Re: SUBMISSION ON THE BRANDY HILL QUARRY EXTENSION PROJECT (SSD 5899)

Council is writing with regard to the Brandy Hill Quarry Extension Project (SSD 5899) at 979 Clarence Town Road, Seaham currently on public exhibition with the Department of Planning. This letter makes reference to the Traffic Impact Assessment report (June 2016) by IntersectTraffic, and the Noise and Vibration Impact Assessment report (August 2016) by Vipac Engineers and Scientists.

Figure 4: Heavy Vehicle Haulage Route

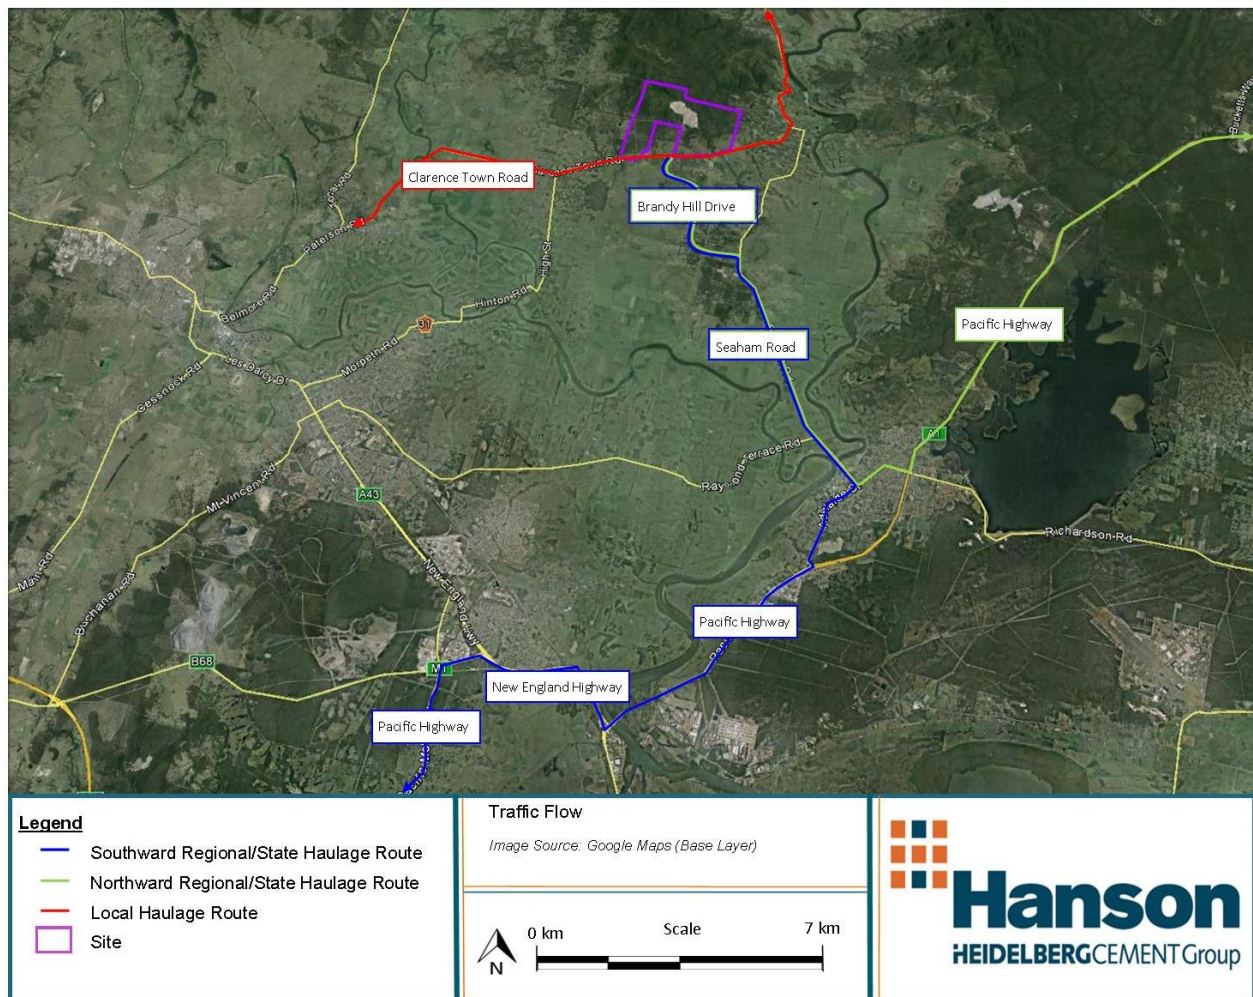
The TIA report states that, "The main haulage route used for transporting the extracted material from the site will not change with all quarry traffic (heavy vehicle) heading south along Brandy Hill Drive to Seaham Road and onto the Pacific Highway at Raymond Terrace." However, "A very small number of trips head west towards Maitland or east towards Clarence Town and Dungog. The westerly route towards Maitland is restricted due to difficulties crossing the Paterson River at Hinton and Woodville."

- Identify the heavy haulage routes for these heavy vehicle trips that are proposed through Maitland LGA; and
- What is the estimated number of heavy vehicle trips expected to travel on any identified haulage routes through Maitland (i.e. through the Maitland local government area)?
